Subject: New comments for application 19/01740/HYBRID

New comments have been received for application 19/01740/HYBRID at site address: Land Adj To Promised Land Farm Wendlebury Road Chesterton

Dear Cherwell District Council Planning Committee Members, Re Planning Application: 19/01746/OUT Land Adj To Promised Land Farm Wendlebury Road, Chesterton In my capacity as chair of the Bicester Bike Users Group (BicesterBUG), I am writing to raise my concerns regarding the inadequate provision of active travel network connectivity with regard to the above outline planning application.

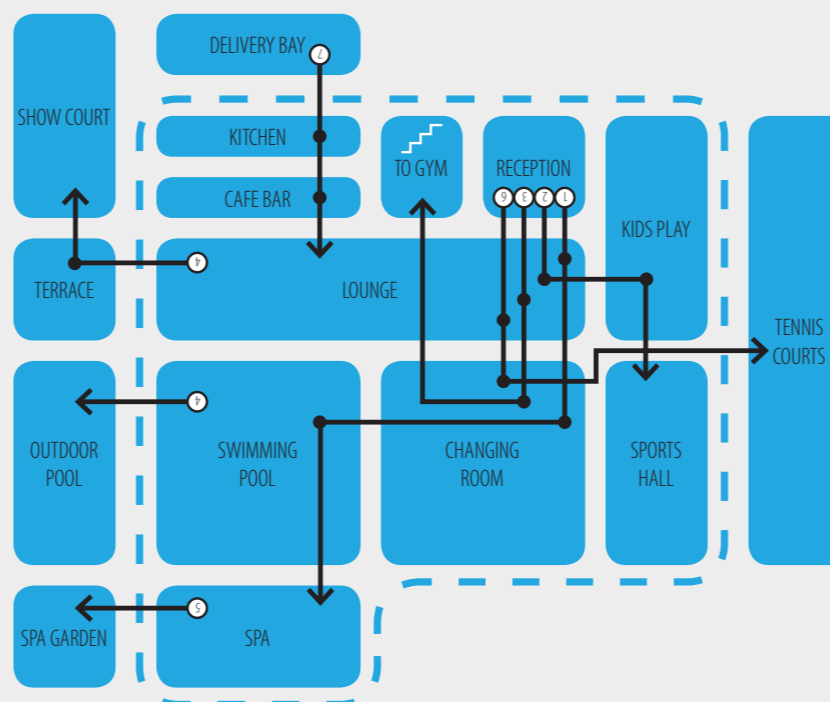
4) 250 car parking spaces and only 20 cycle spaces are described, and is likely to contravene the OCC guidelines of 1 space per 150m<sup>2</sup>. We would request that more ambition is shown rather than hitting minimum standards. The security and accessibility of the cycle parking is also a concern.

Figure 6 – Proposed Pedestrian Route

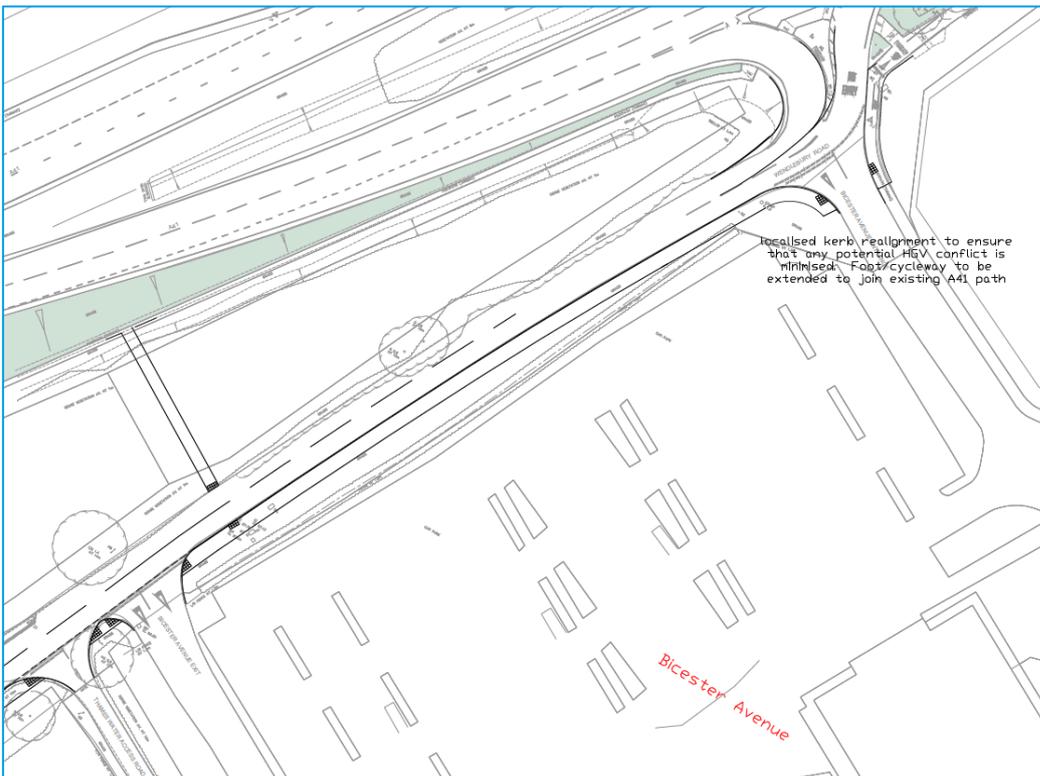
2) The development includes a significant section of NCN51 along Wendlebury road. The plans claim to improve the cycling provision but indicate only a mixed use path of 2.5 m width without cycle priority at side junctions; therefore not in accordance with the Cycling Design Standards.(6) We believe this is a significant impediment to the current situation which would result in increased cycling times and discourage active travel along this section.

**Drawing Number 19539-18 Rev E**

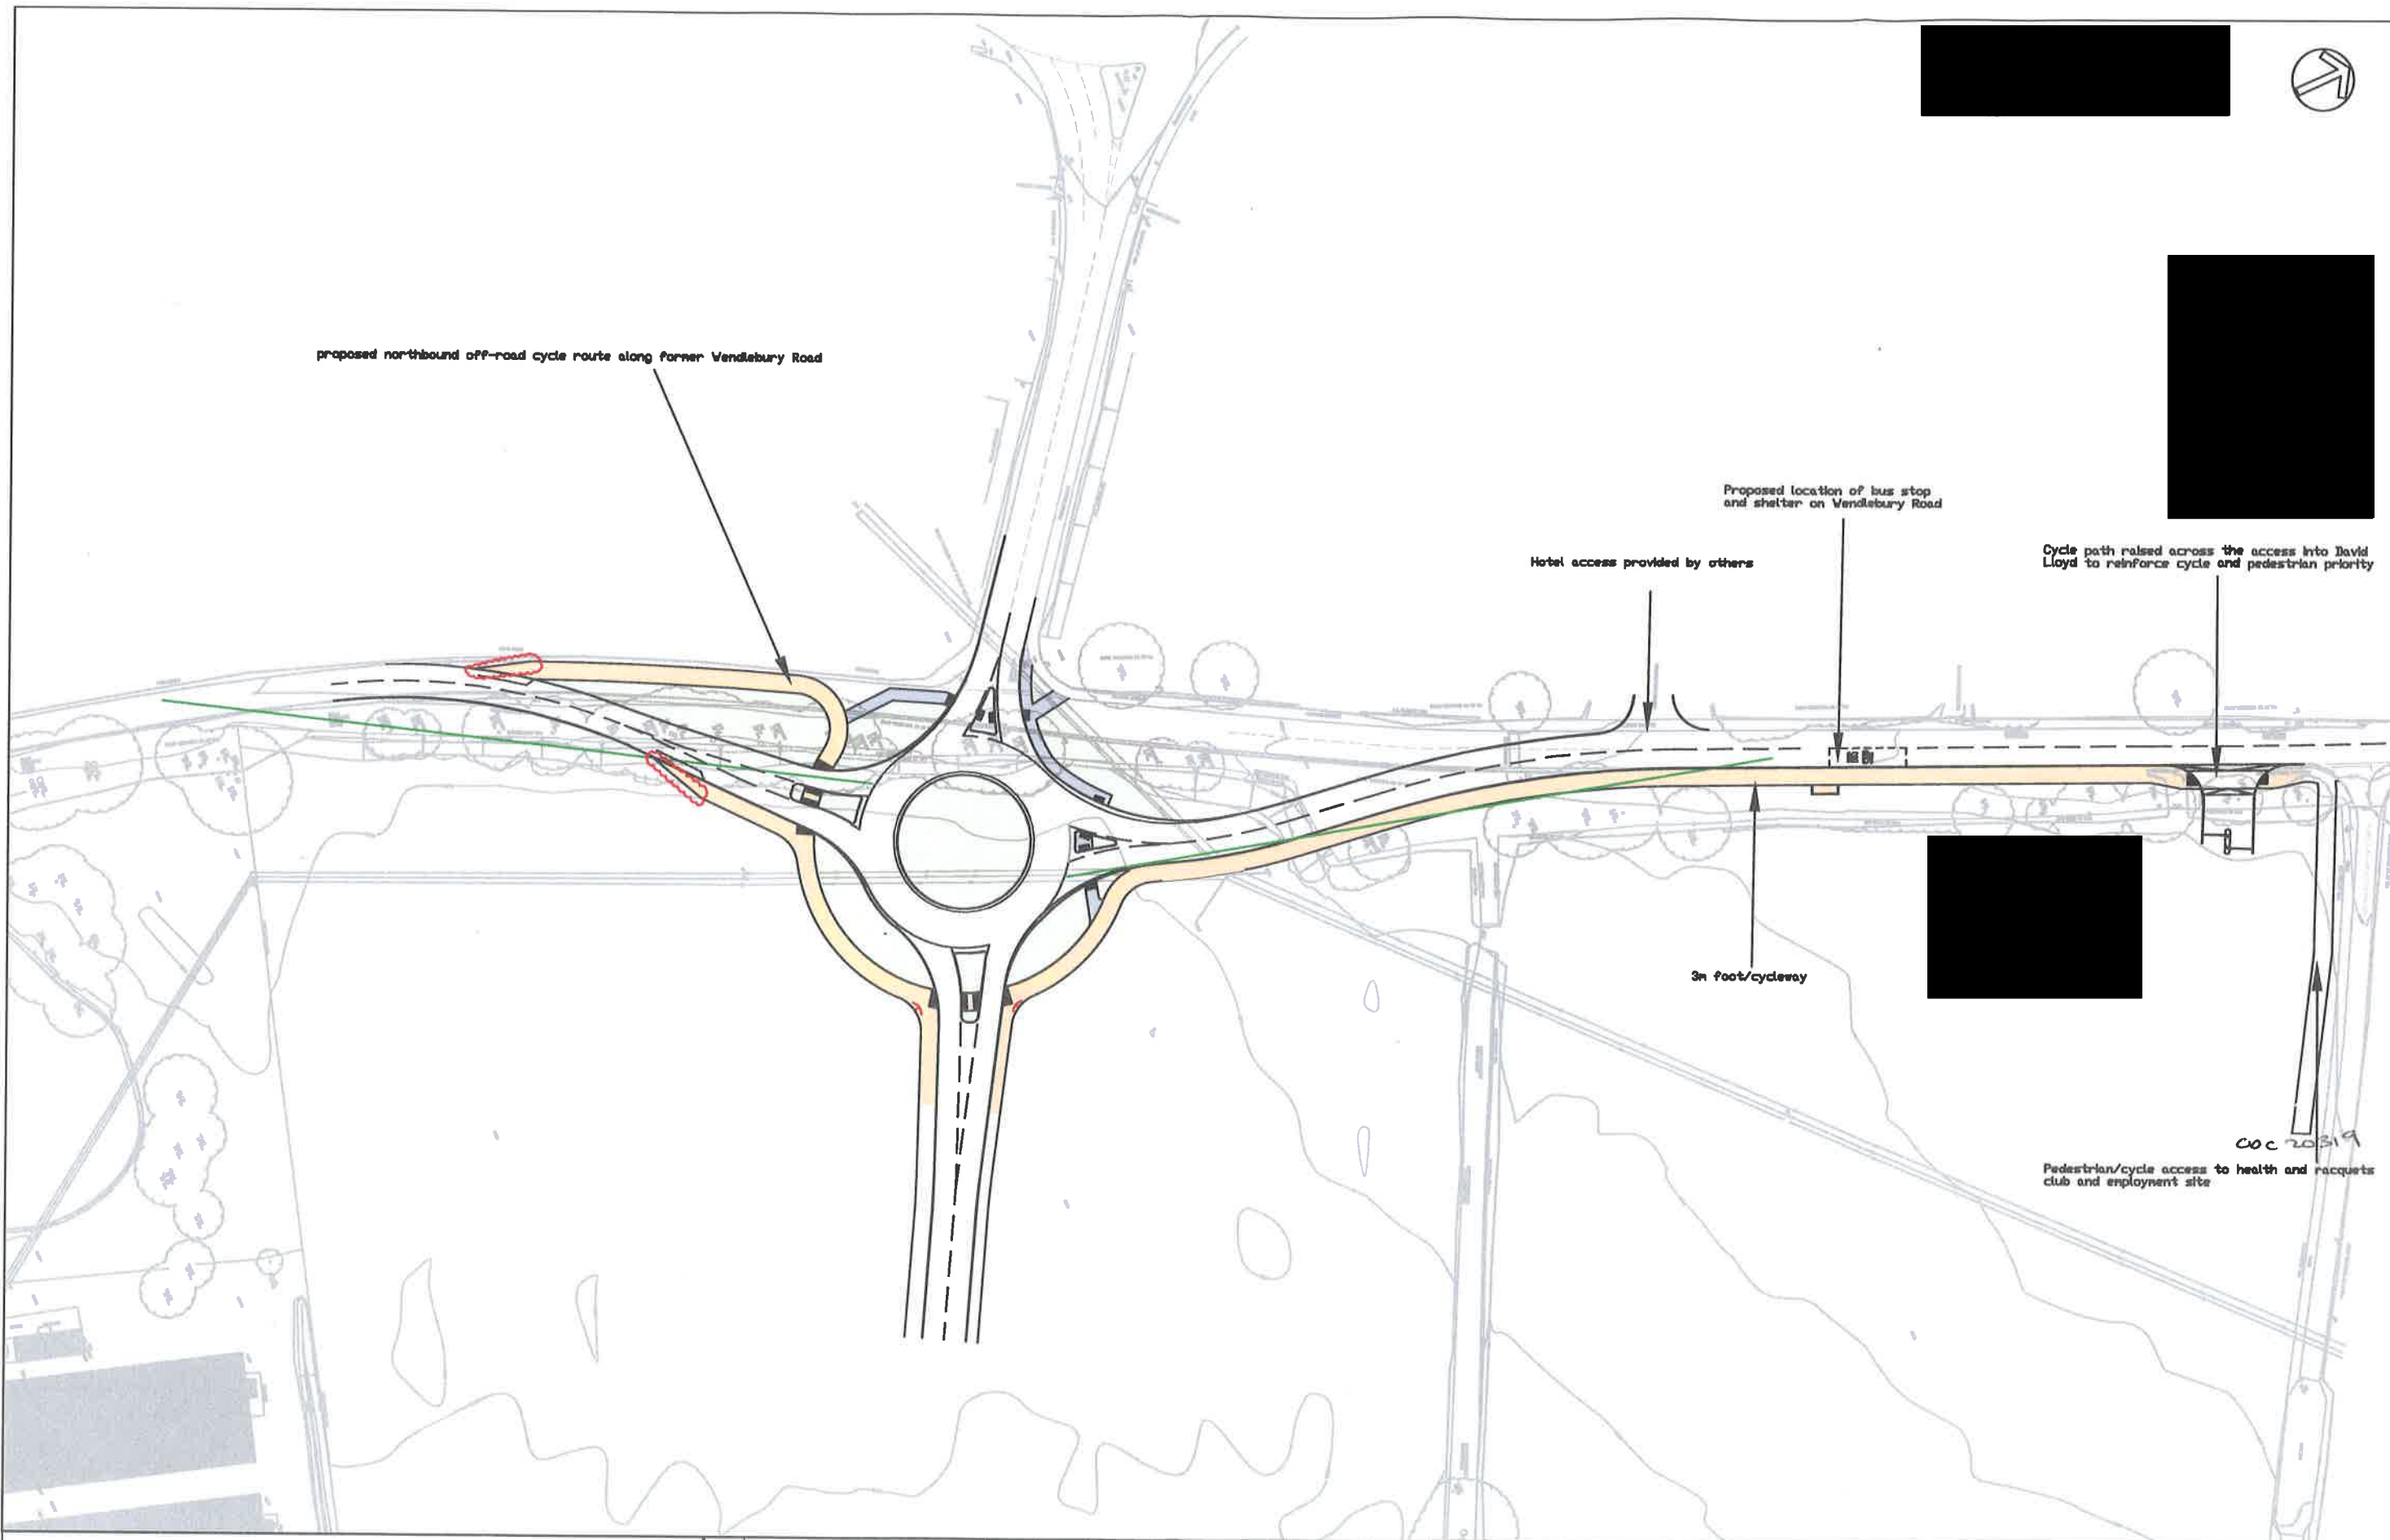
3) Given the additional car and HGV traffic (quoted as being 600-1800 cars per hour and 1000-3000HGVs per day ) then a segregated cycle path with priority over the adjoining roads in a 'dutch style' roundabout should be considered. BicesterBUG rejects the claim that the traffic level is below a supposed 'intimidation threshold', new and unsure cyclists would be actively discouraged by the planned changes and increases in traffic from travelling in the area.
